Whitehead & Associates
Environmental Consultants

Our Ref: 3324_Peer Review Letter_001

Peer review of Wastewater Management Assessment for proposed Commercial Development at Catherine Field, NSW 2557

This document forms a review of the Wastewater Management Assessment report (the “Martens report” or “WMA”), prepared by Martens Consulting Engineers for the proposed Minarah College (the “College”) development at 268 – 278 Catherine Fields Road, Catherine Field NSW (the “Site”), along with response submissions from Camden Council (“Council”) and Sydney Water.

Figure 3 Stage 1: Onsite Treatment and Irrigation (Martens & Associates 2022).

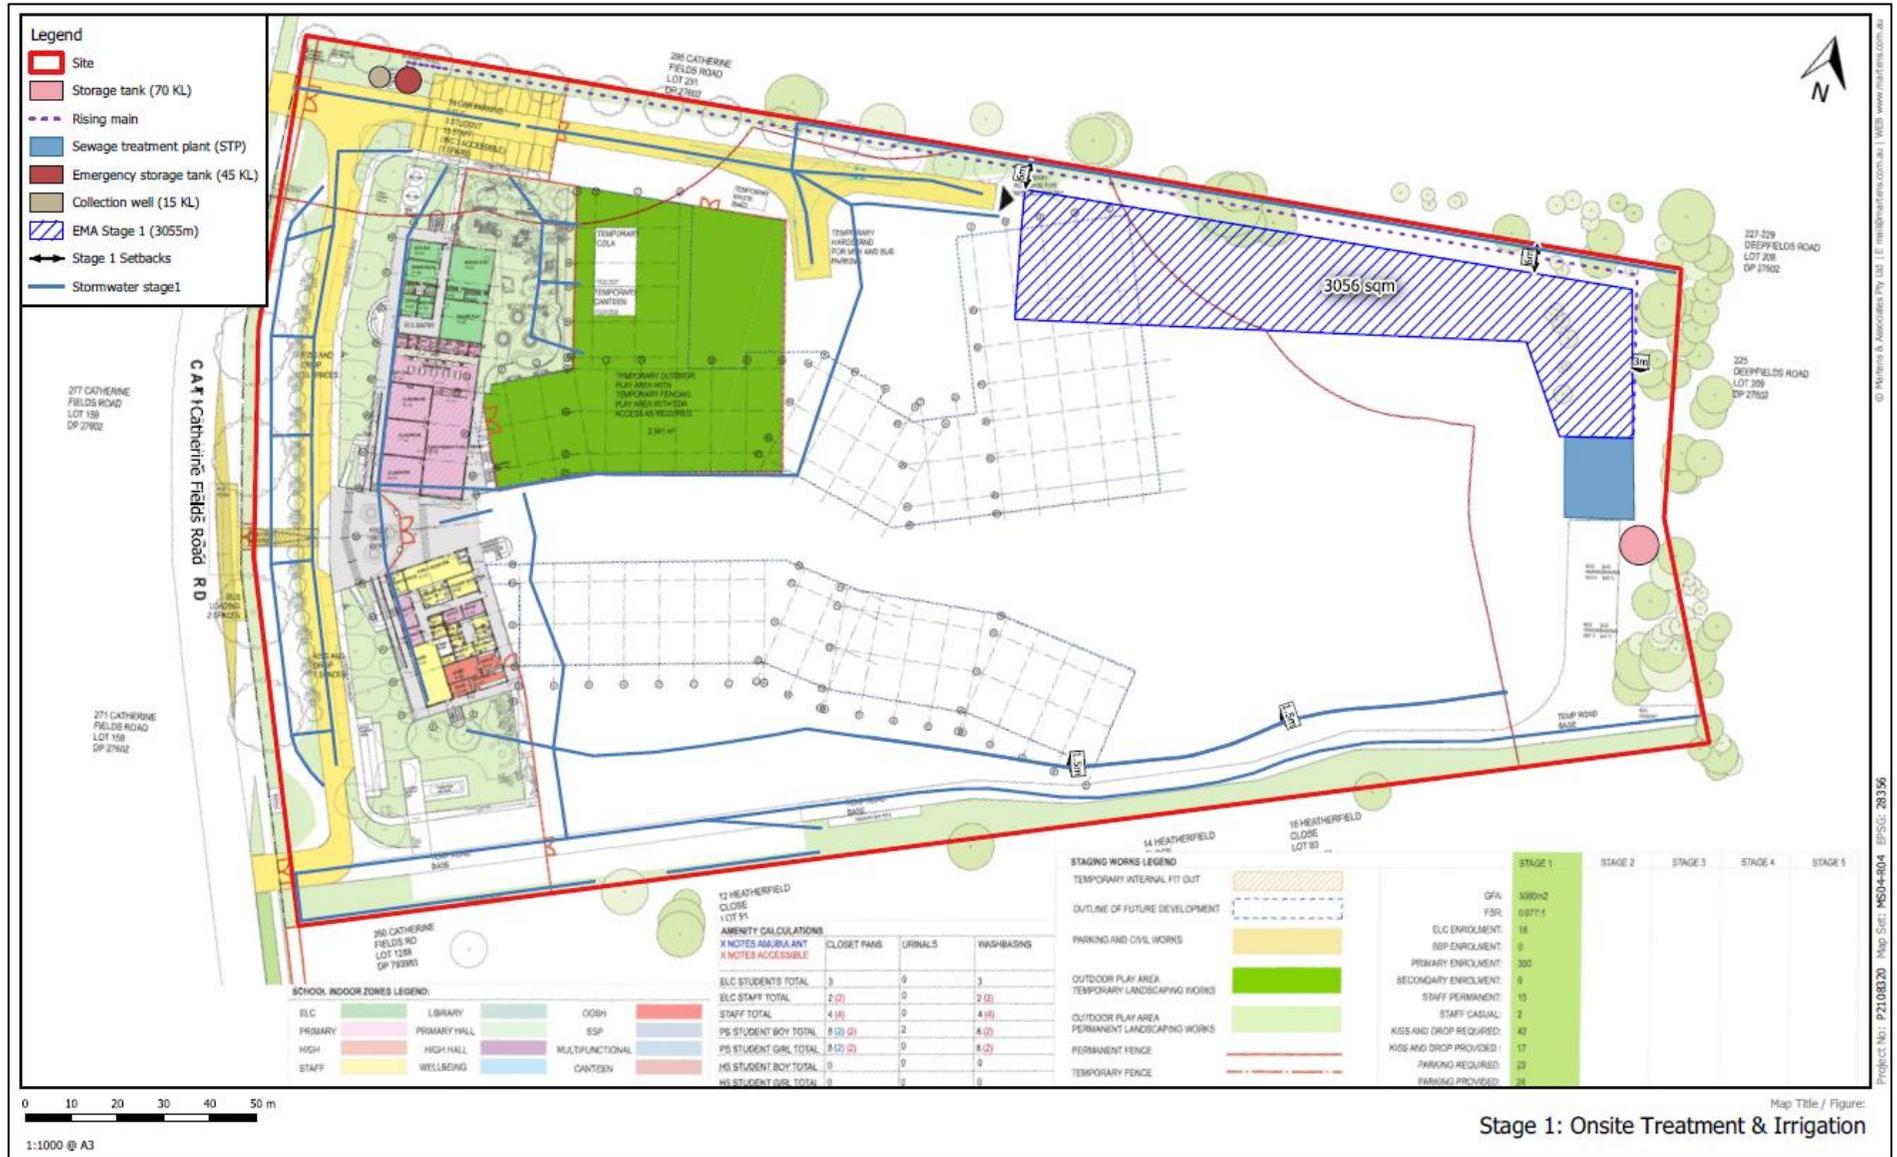
The proposed (Stage 1) EMA will be located on the natural soil profile in the northeast of the Site. Plans indicate that 'no filling' of the EMA will occur during Stage 1 works; however, fill material will be added to the already established Stage 1 EMA location during later earthworks.

Natural topsoils in the vicinity of this location consist of clay loam (Cat 4) to a depth of 0.1m (BH109) and 0.3m (BH113). W&A recommend that the Stage 1 fill plan is modified to include the provision of a (minimum) 0.3m topsoil depth throughout the EMA.

Care should be taken to ensure that only native topsoil material is added to this area (no subsoil).

It is noted that the required 40m setback to 'other waters' is not practically achieved for the identified Stage 1 EMA, with a partial encroachment in the north-east corner of the Site (refer Figures 1 and 2, Appendix A).

This can be rectified with a minor modification to the proposed Stage 1 EMA in the WMA report.

Figure 4 Stage 2: Onsite Treatment and Irrigation (Martens & Associates 2022).

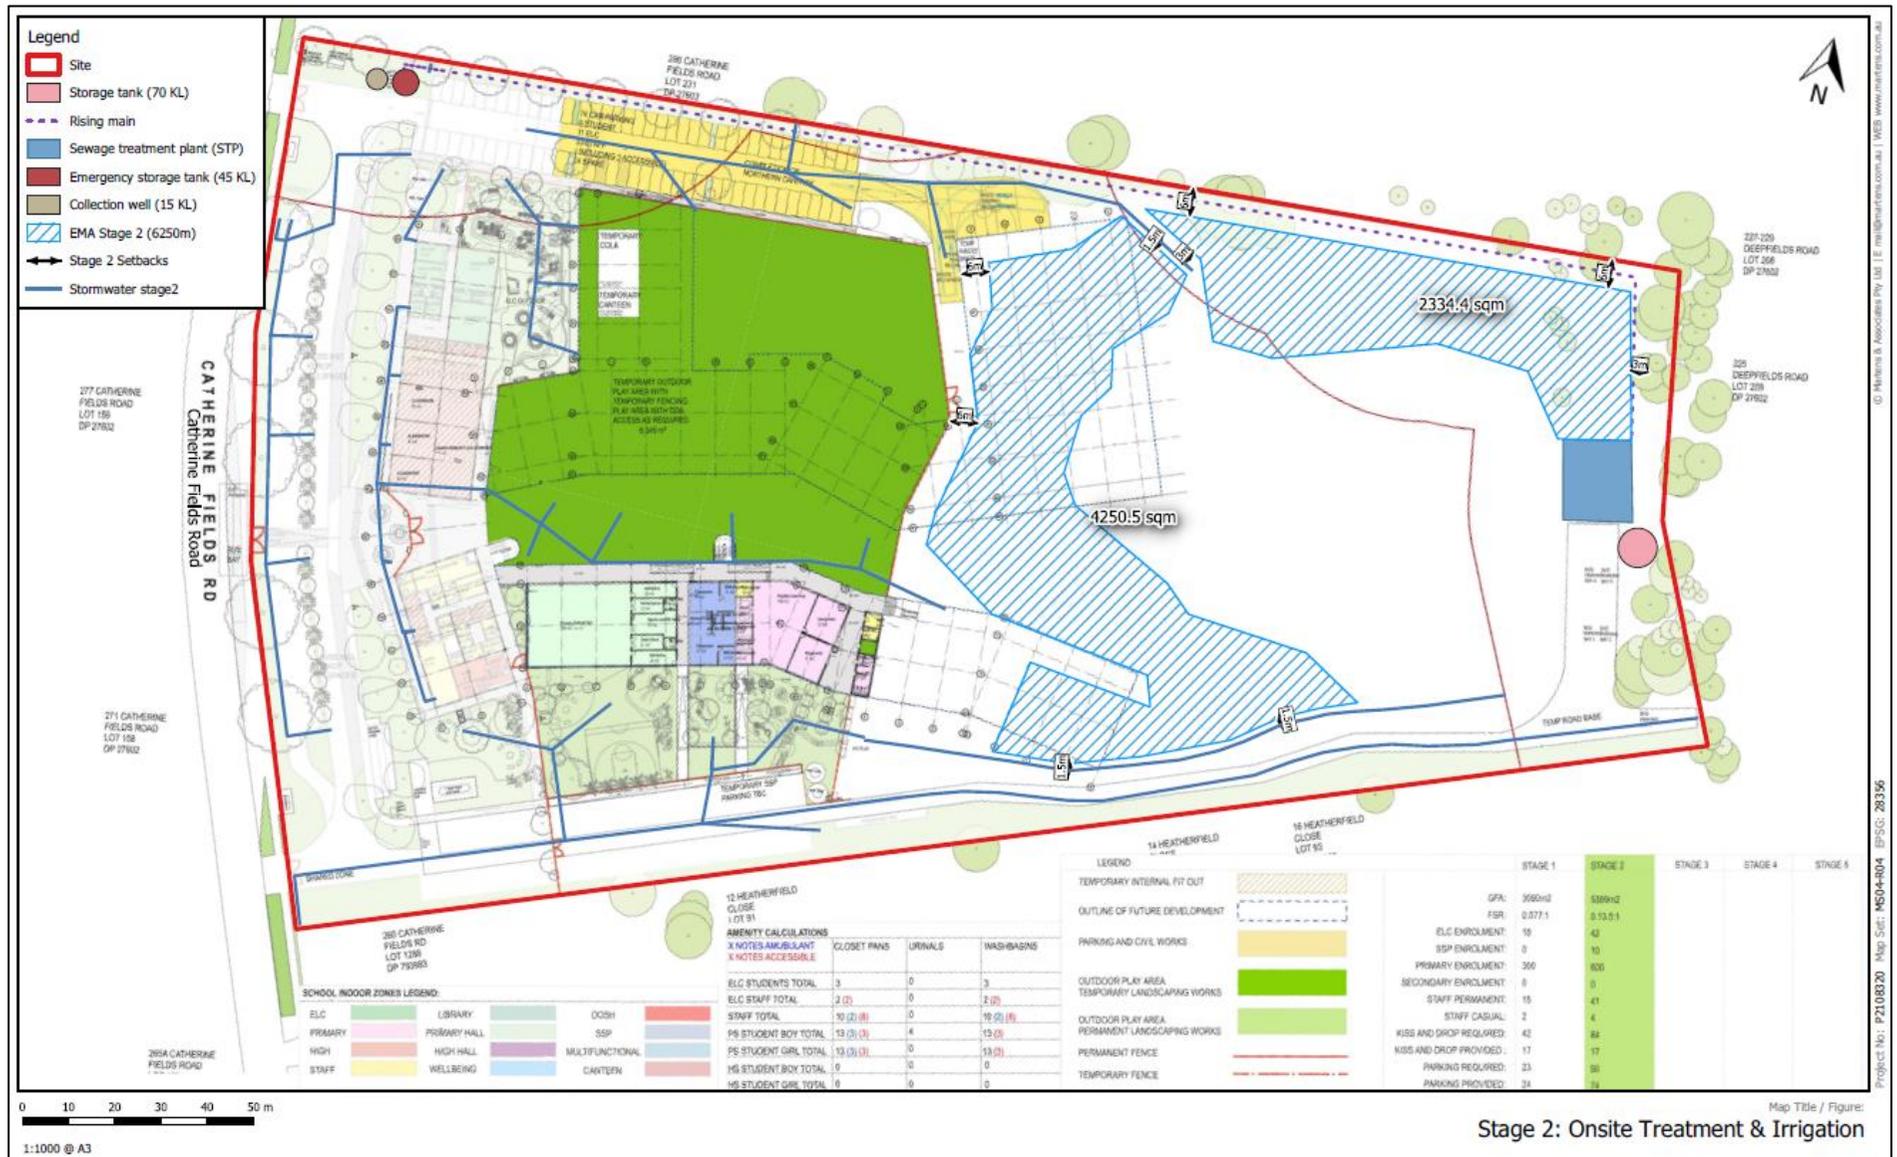
The proposed (Stage 2) EMA includes areas of variable cut (-0.15m to -0.75m) and fill (0.15m to 1.5m) in the centre of the Site. While filling may increase the available topsoil depth, excavation (cut) will expose the underlying (Cat 5) light clay subsoil material.

The WMA recommends the addition of 0.3m (minimum) of 'suitable' topsoil in proposed EMAs where cutting or filling works have exceeded 1m.

W&A recommend that this procedure is expanded to include all areas where effluent application is proposed to ensure that satisfactory soil depth is available for irrigation installation and effluent assimilation. This approach is consistent with *AS/NZS 1547:2012*, requiring a minimum 150mm-250mm of "in-situ or imported good quality topsoil" for irrigation lines installed over Category 5 soils to slow seepage and assist with nutrient uptake.

Further, it is recommended that 'in-situ' topsoil from cutting works is stockpiled from the Site and used for improvement of EMA locations prior to installation.
